**Subject:** Toddington Lane Scheme (Application ref. LU/246/24/PL) – Response to comments on Ecology and Biodiversity

Land at Toddington Lane Littlehampton BN17 7PN.

I have reviewed this application with regards to ecology and Biodiversity Net Gain.

**Figure 1.** Proposed landscaping plan for the development at Land at Toddington Lane, reproduced from Studio gb, dated September 2024 (drawing no. TLN-SGB-00-GF-DR-L-101).

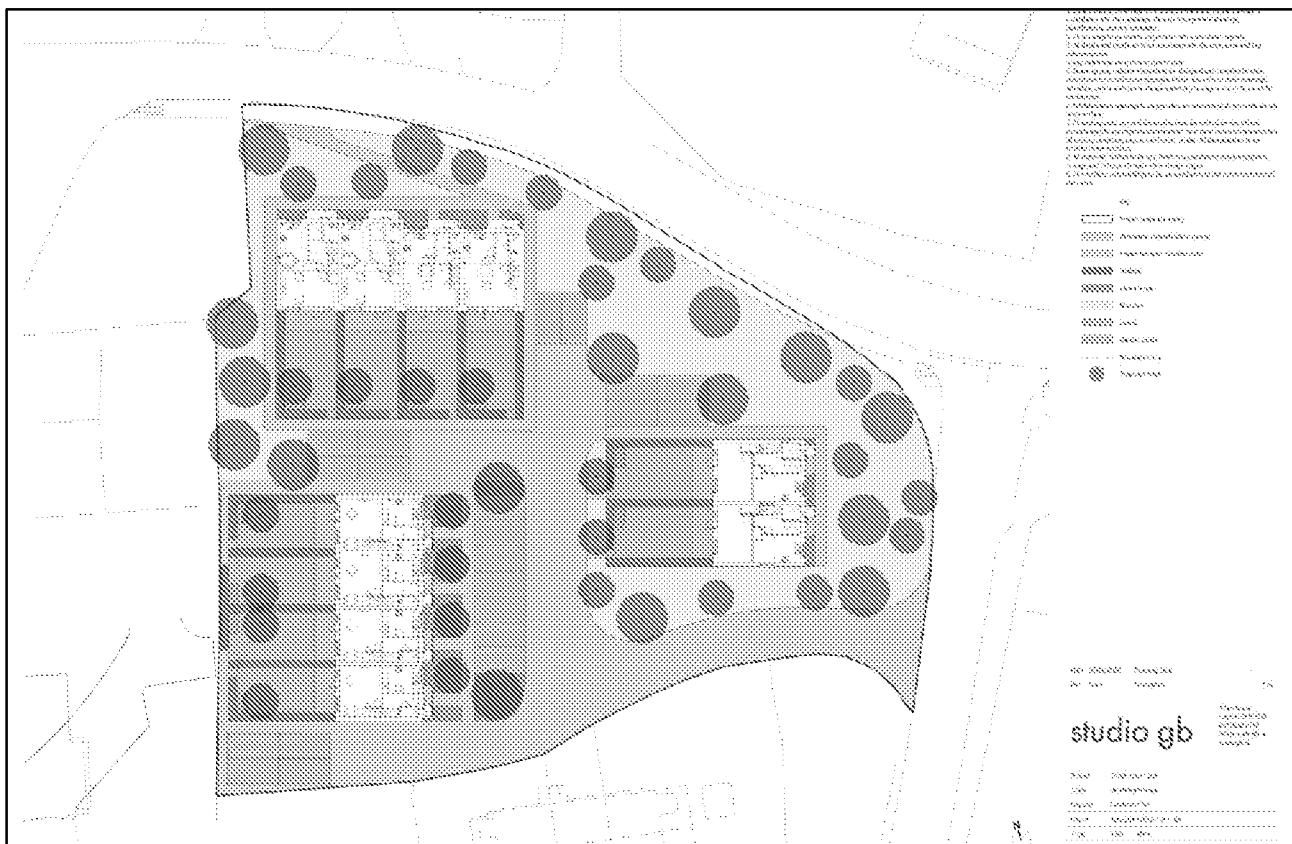
Currently no onsite habitat is being retained. Options should be explored to see if the shortfall can be achieved on site first. This is consistent with the principle of considering biodiversity from the beginning of the development process. The proposed reptile translocation highlights this as the requirement to translocate the reptiles could be mitigated onsite by retaining some of the suitable habitat.  
The hedge could be extended to run along the western boundary.

In regard to the suggestion of extending the hedge along the western boundary, whilst this would improve the biodiversity value of the site, this would not be in relation to habitat areas under BNG, it would come under hedgerow, which wouldn't count towards the current BNG shortfall highlighted. Moreover, there is not currently enough space to create a scrub habitat in this area.
